# BCA Assessment Report

200 Aldington Road, Kemps Creek  
Warehouse W4A & W4B, Lot E

SSDA – 85510213  
MOD 6

**Revision 2**  
3 October 2025  
Reference: S250200

GROUND FLOOR PLAN - OFFICE - W4A
1:100

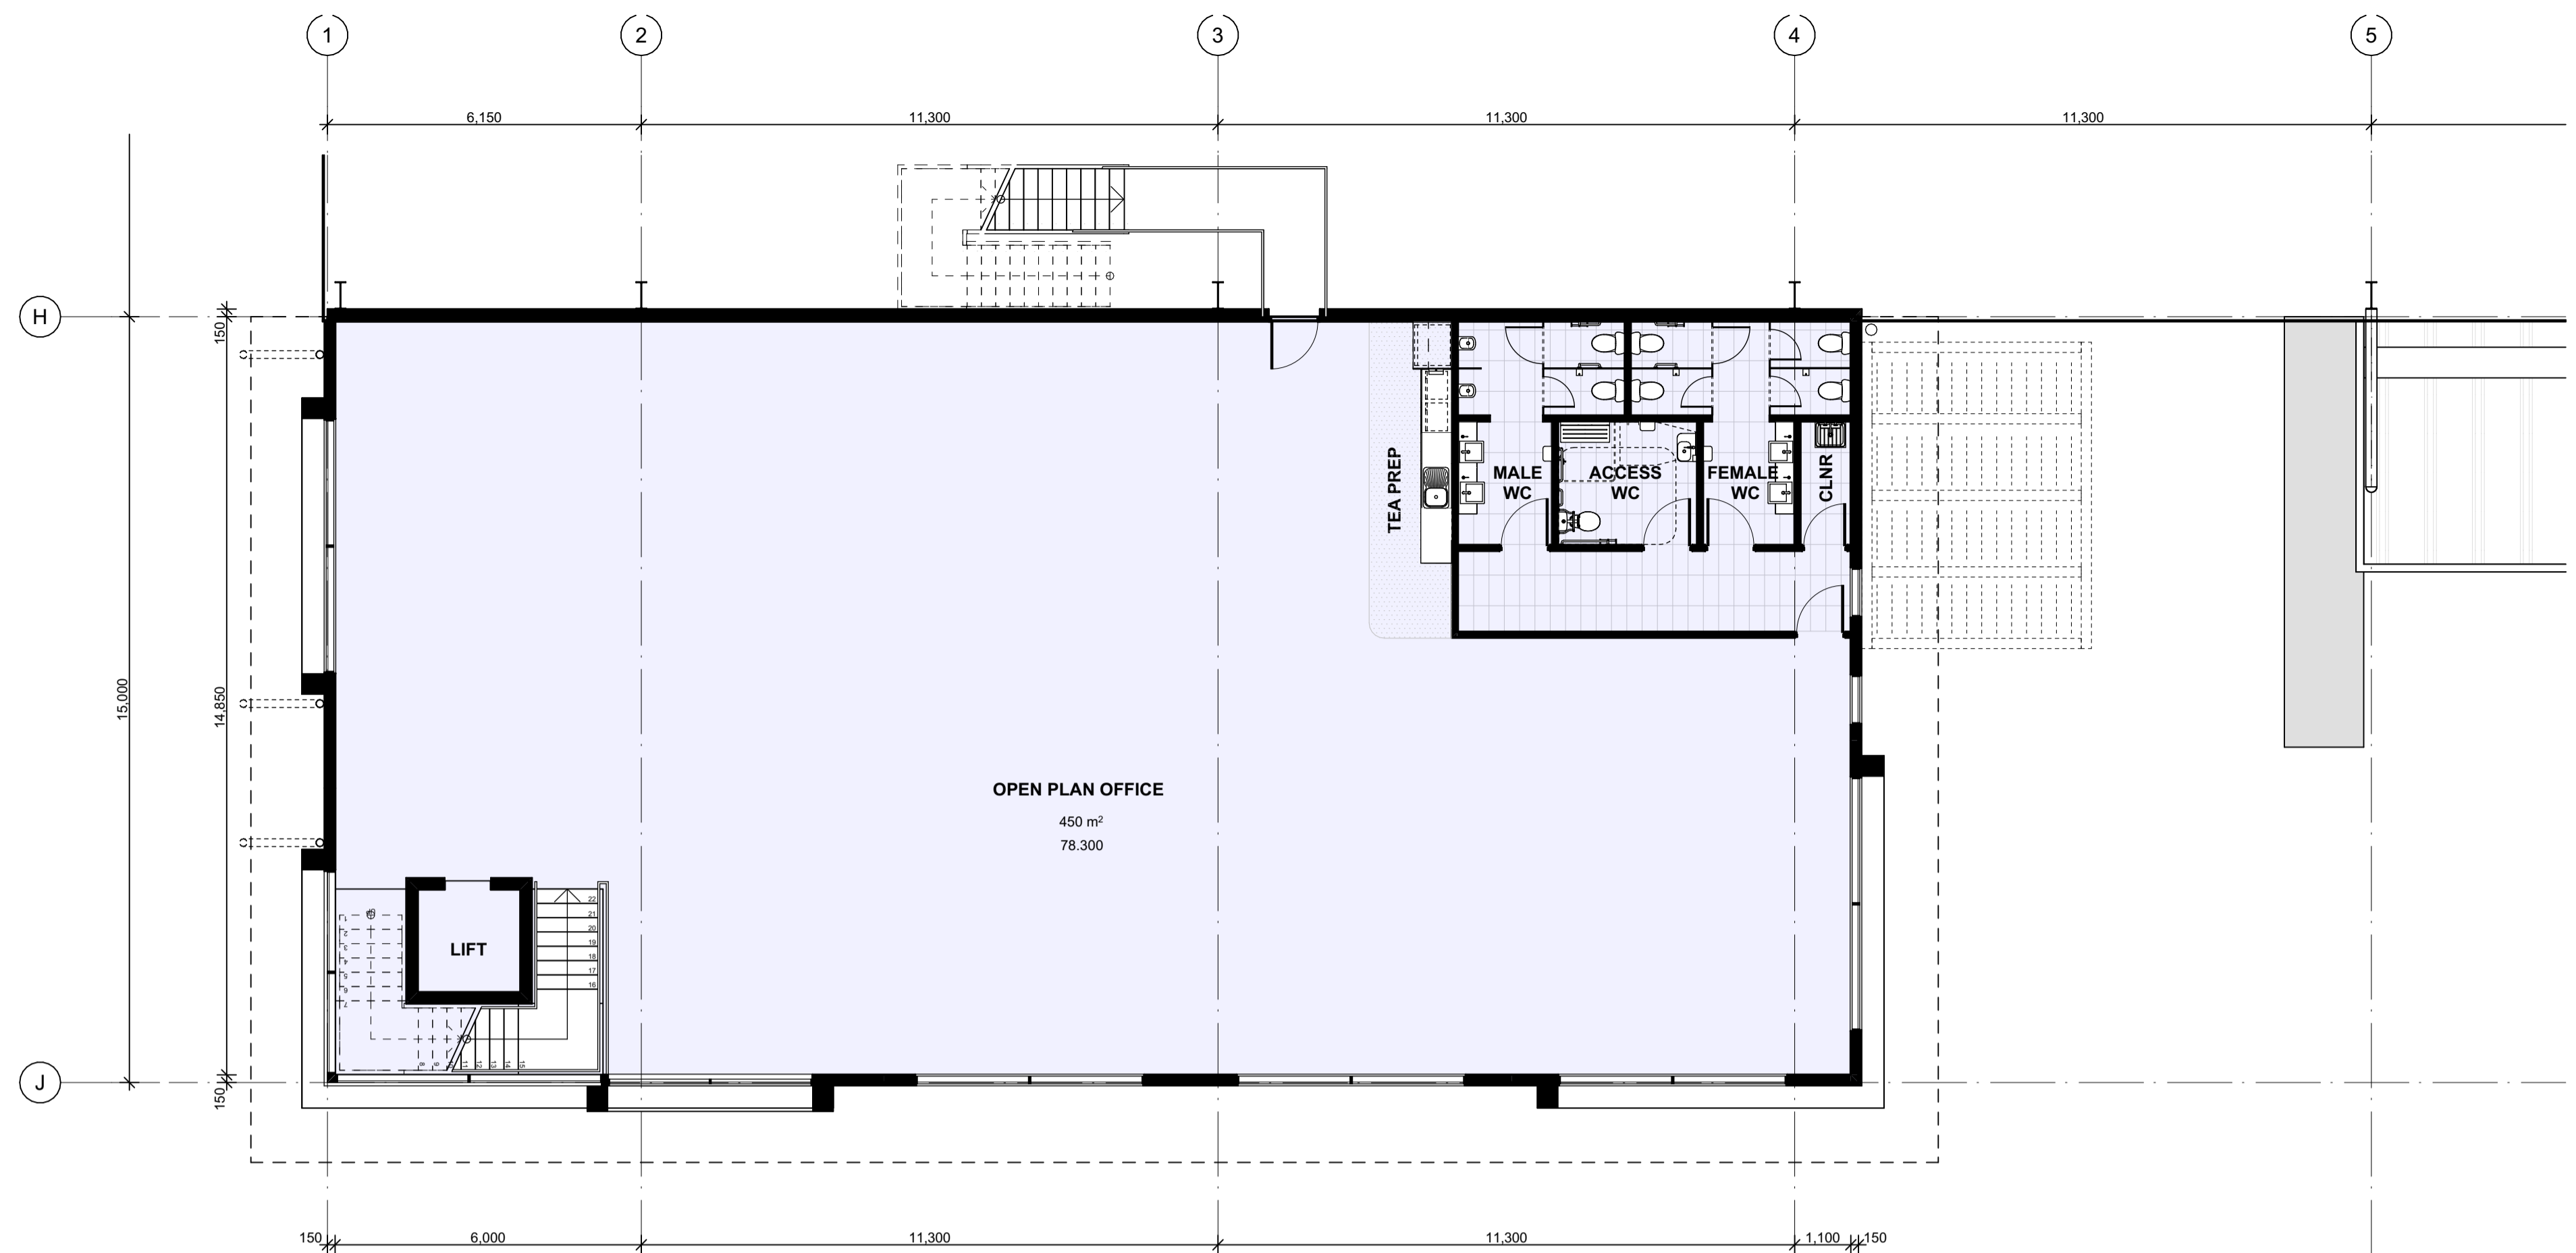
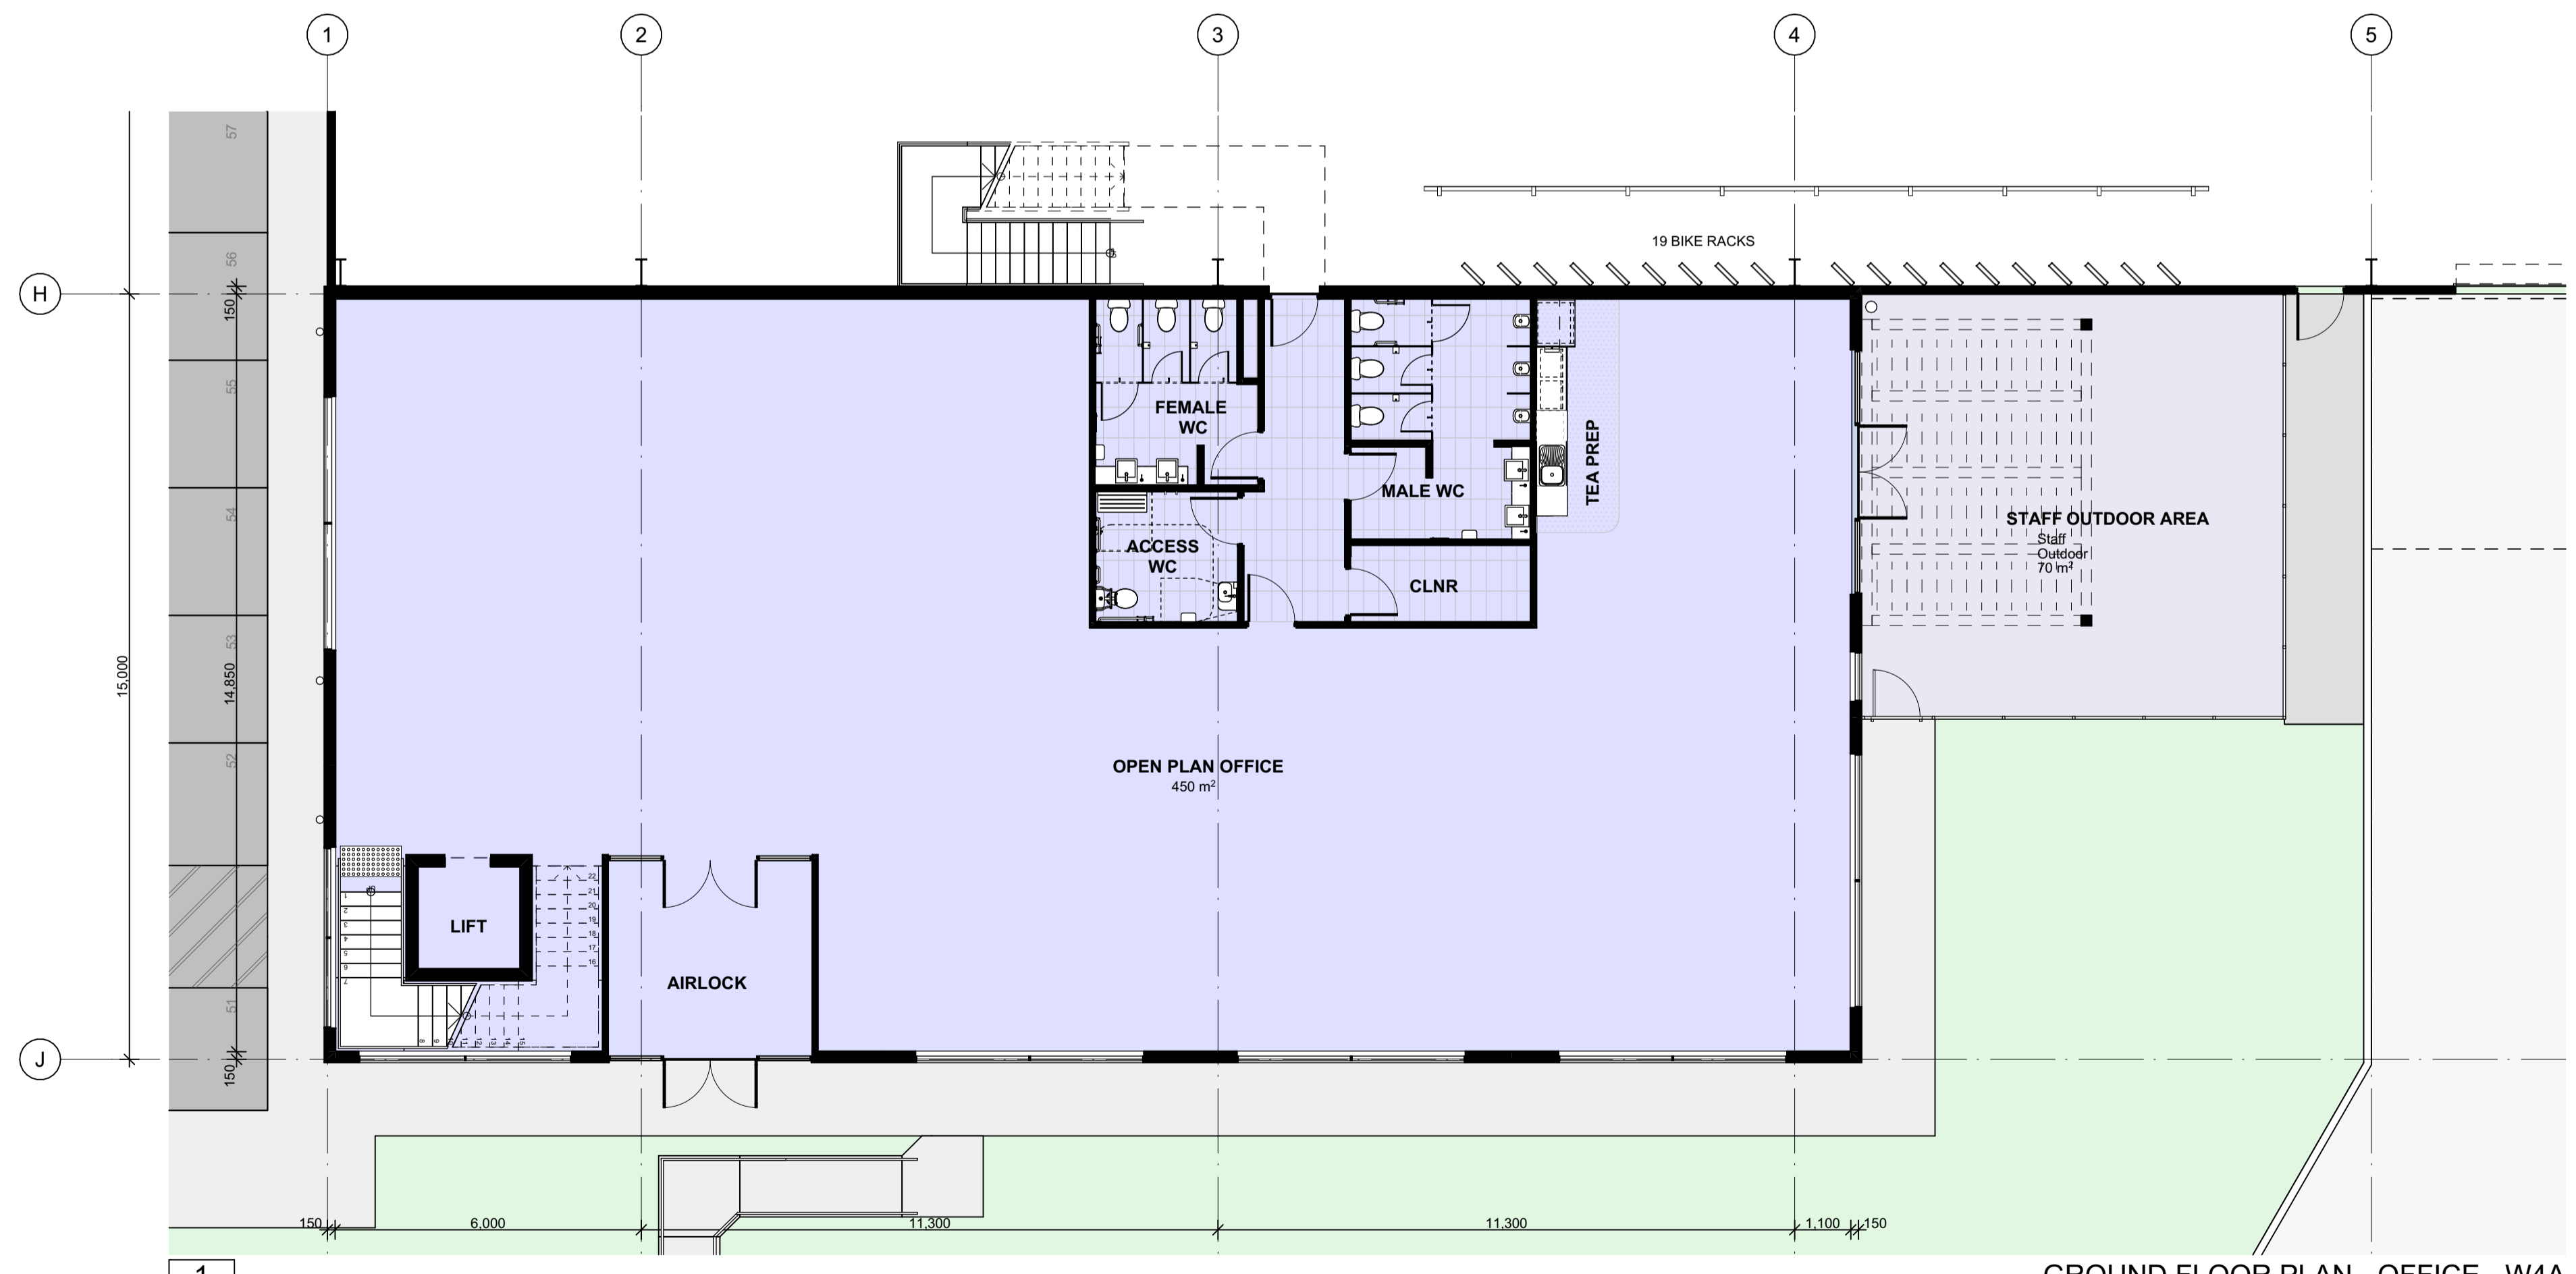
3. D2D5 / D2D6	An additional door exit door will be required to WH4A adjacent the sprinkler pump room to provide egress distances complying with FRNSW max 100m distance to an exit requirement.
